**From:** Steve Hunting   
**Sent:** 25 November 2014 15:10  
**To:** Anita Gardner  
**Subject:** FORT ROAD EAST (LU/161/14/PL)

**From:** Anita Gardner  
**Sent:** 03 October 2014 16:59  
**To:** 'Steve Hunting'  
**Subject:** RE: FORT ROAD EAST Planning Application LU 161 14 PL

**From:** Steve Hunting [REDACTED]  
**Sent:** 02 October 2014 14:46  
**To:** Anita Gardner  
**Cc:** Terry Mills  
**Subject:** FORT ROAD EAST Planning Application LU 161 14 PL

**From:** Sue Loveday  
**Sent:** 26 June 2014 11:59  
**To:** Anita Gardner  
**Cc:** Paul Broggi  
**Subject:** Planning Application LU 161 14 PL

PROJECT: Proposed Light industrial development at: Fort Road East, Littlehampton.
DRWG TITLE: PLANNING Site location and Block plans
CLIENT: Mr T. Mills

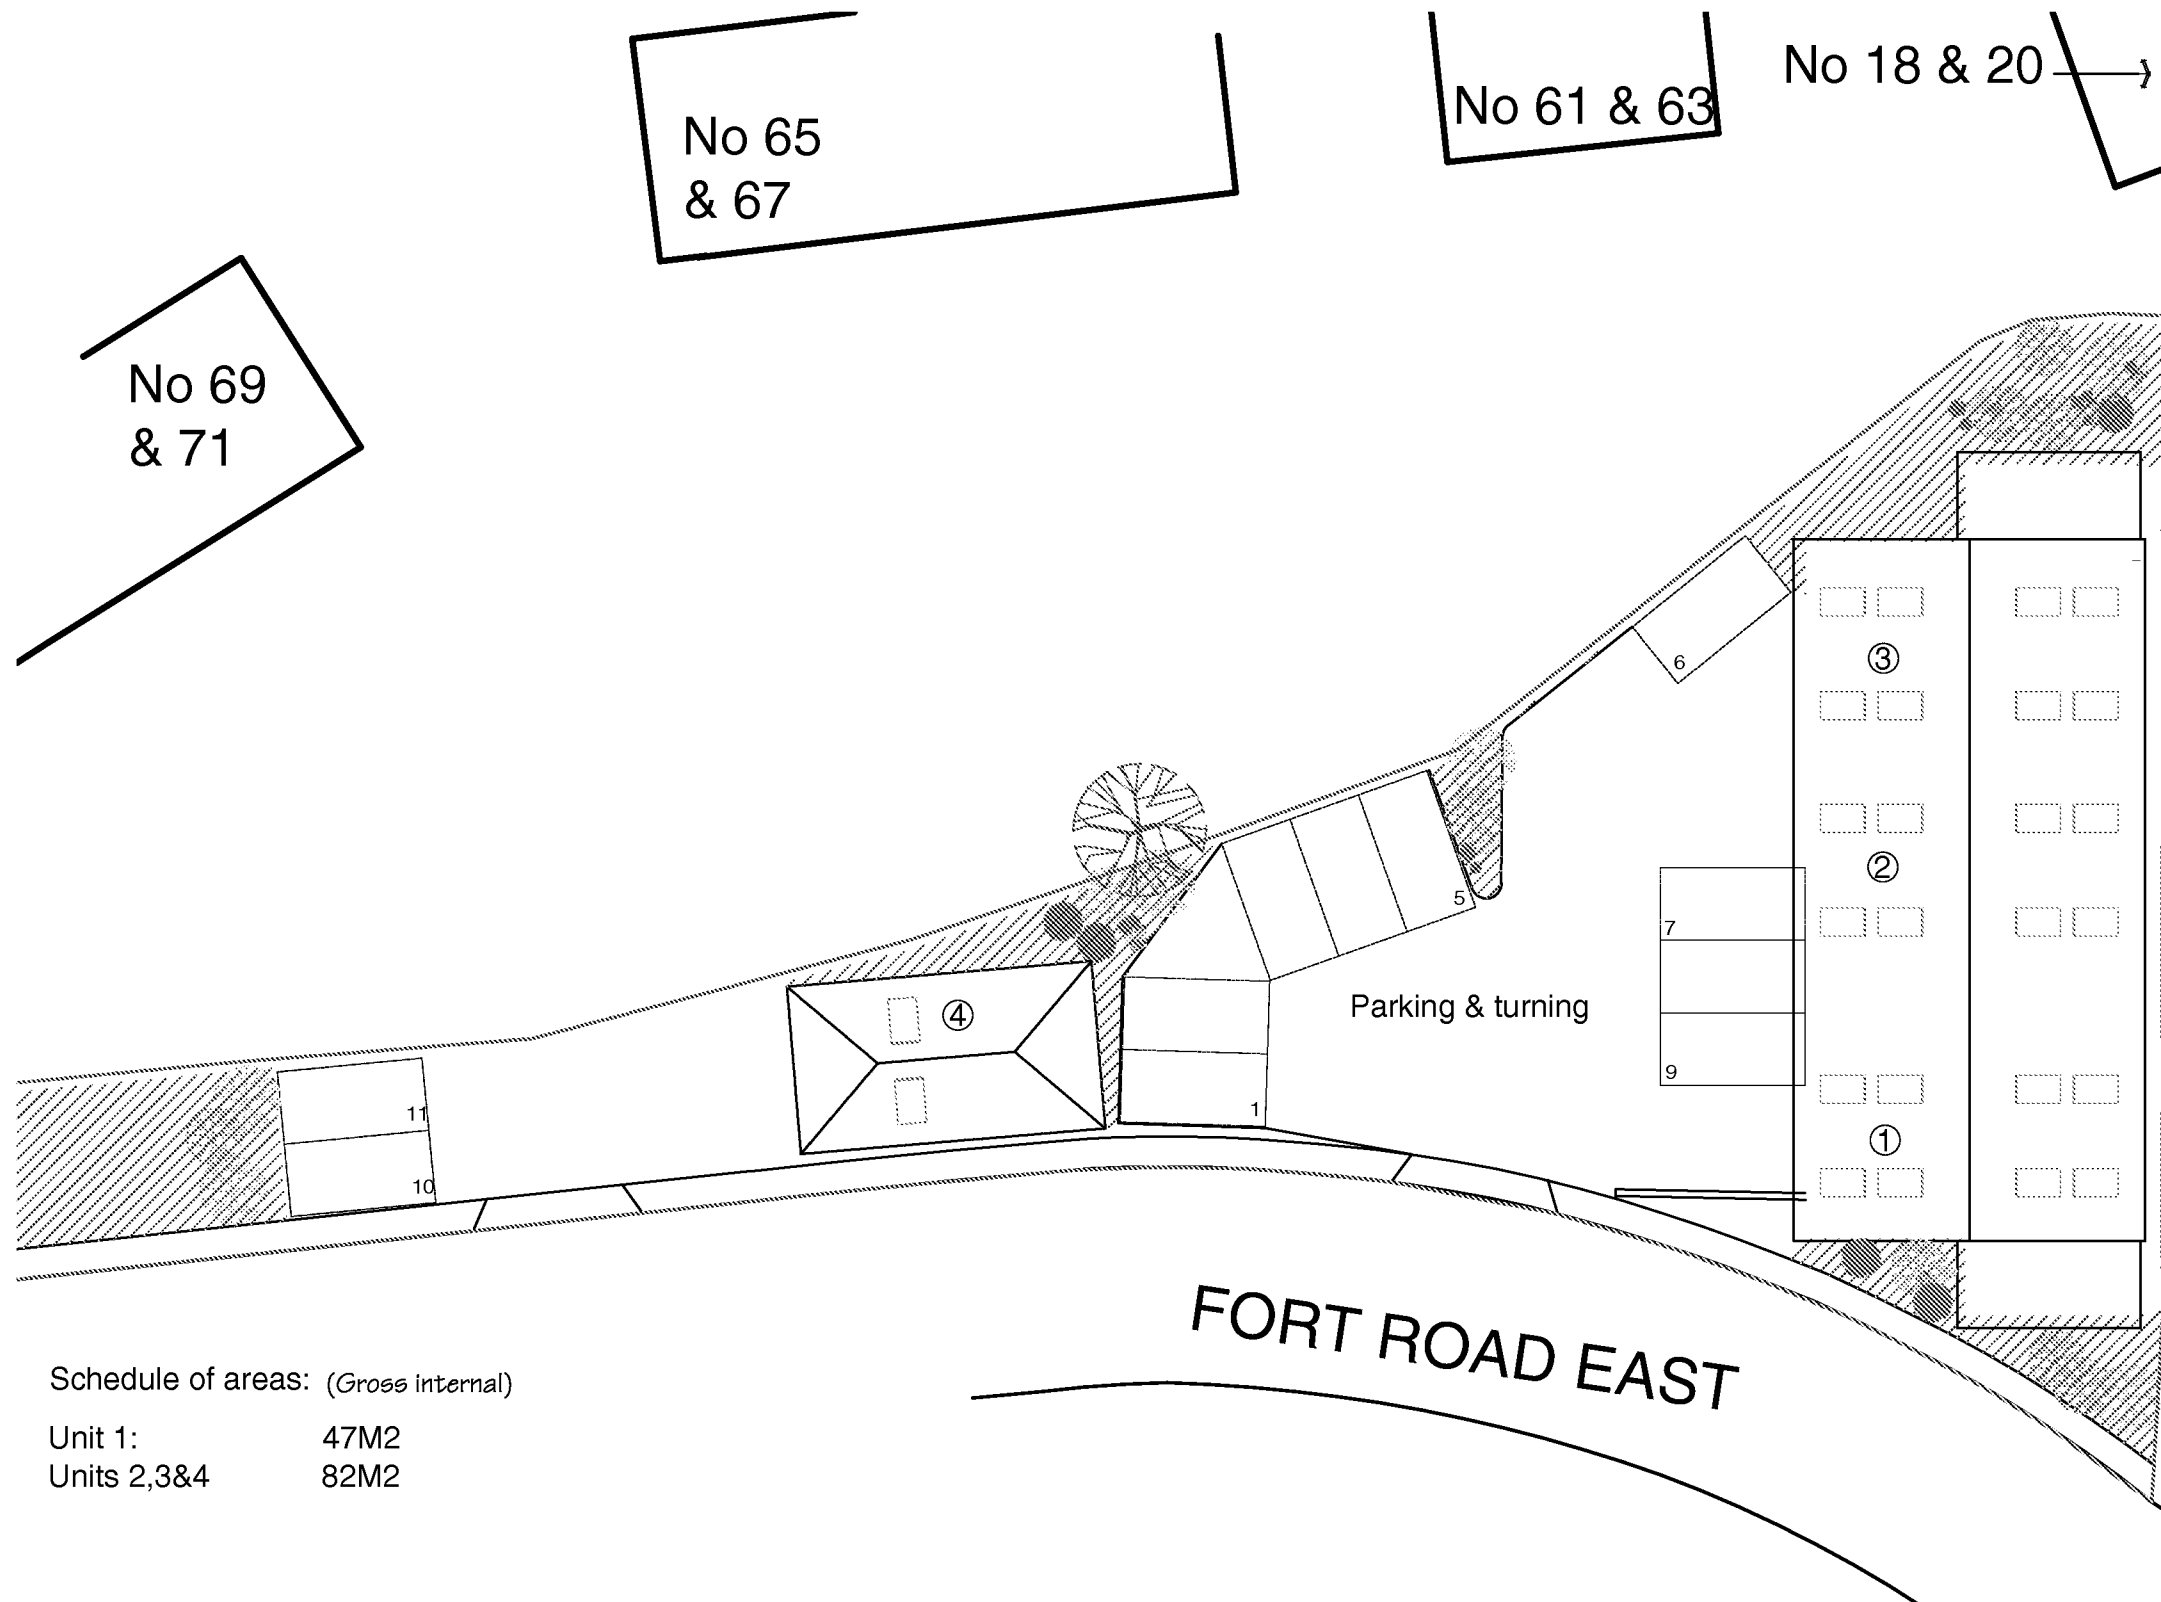
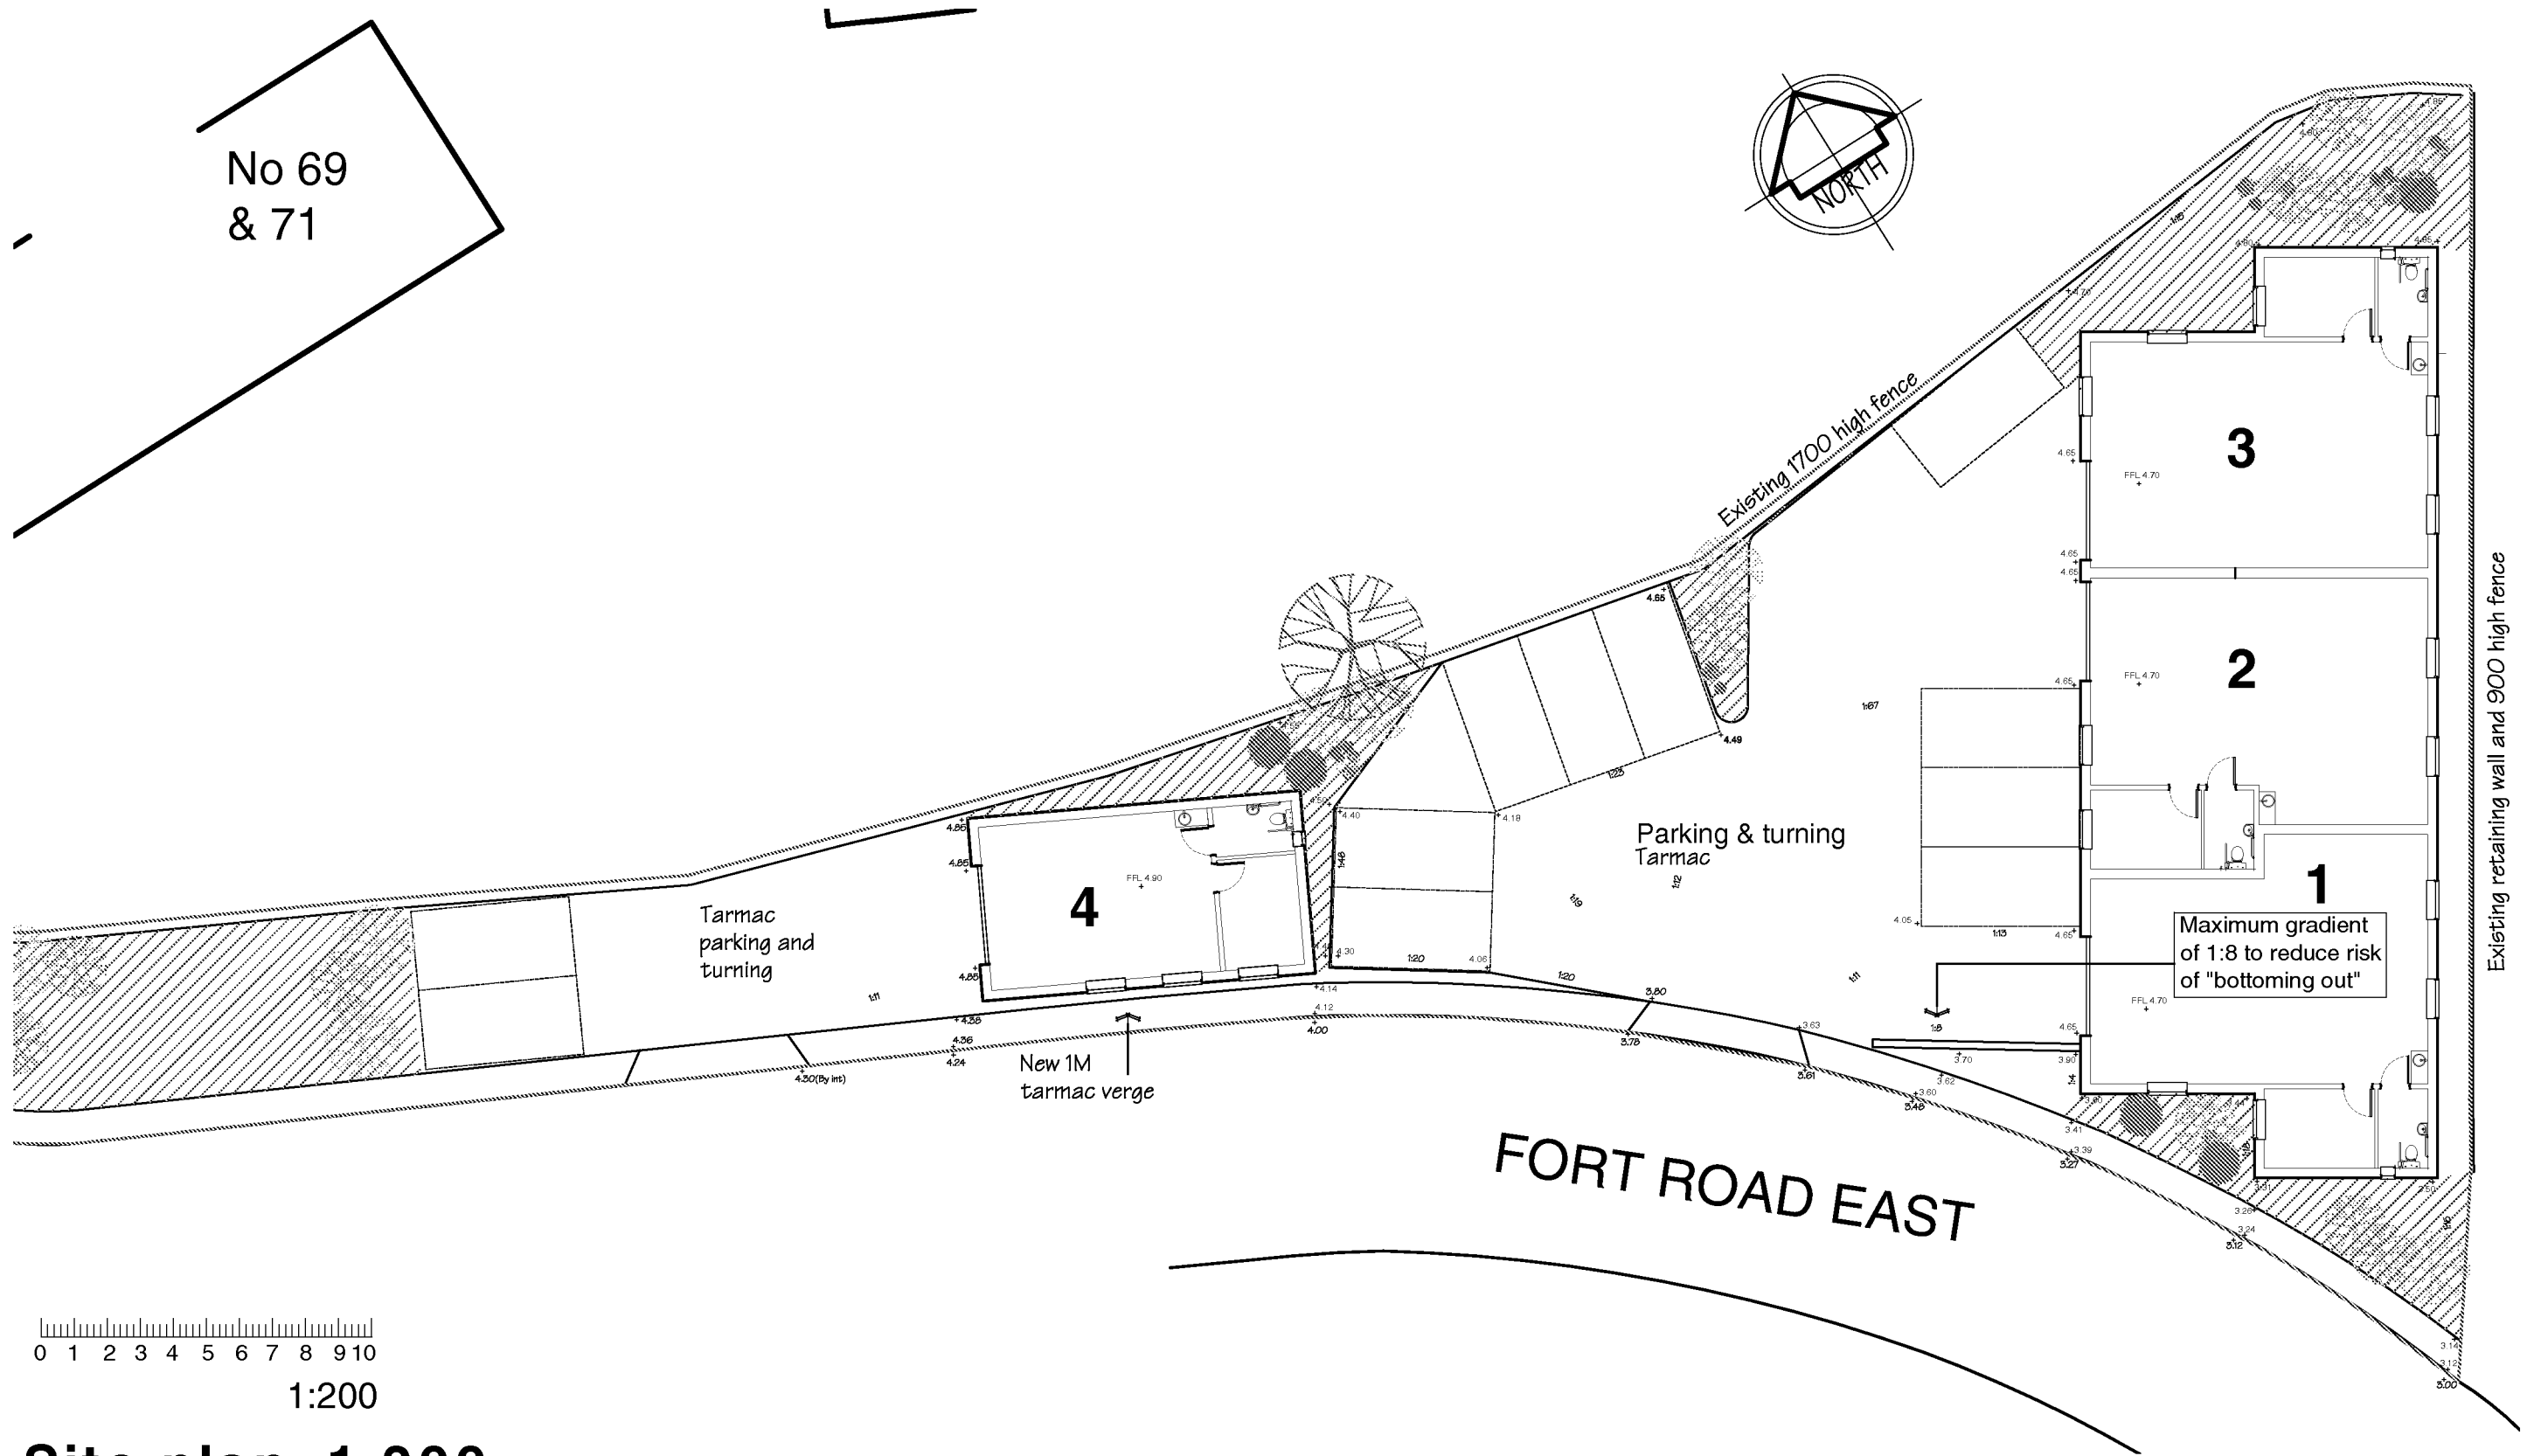
The application has been returned to me today. Unfortunately the revised site plan has a different red edge to the block plan and they need to be the same. Since you have submitted Certificate B all of the site can be red edged to include land that is not in your client's ownership. Please let me have revised block plan by Wednesday or the application will have to be pulled off next week's weekly list.

Further to our telephone conversation, I confirm that the plan provided by the Applicant, for development of the above site, includes land in The Council's ownership. I attach a plan which outlines in green the extent of that ownership.

As freeholders of the land proposed for parking and turning, we would expect to receive formal notification from the Applicant, which we have not received.

Since your clients do not own the land where the parking and turning is indicated either the red edge to the application site and layout should be amended which will entail withdrawal and resubmission of the application or Notice should be served on the Council and a Certificate B submitted.

I attach a certificate B along with revised drawing 02B and trust the application can now continue.
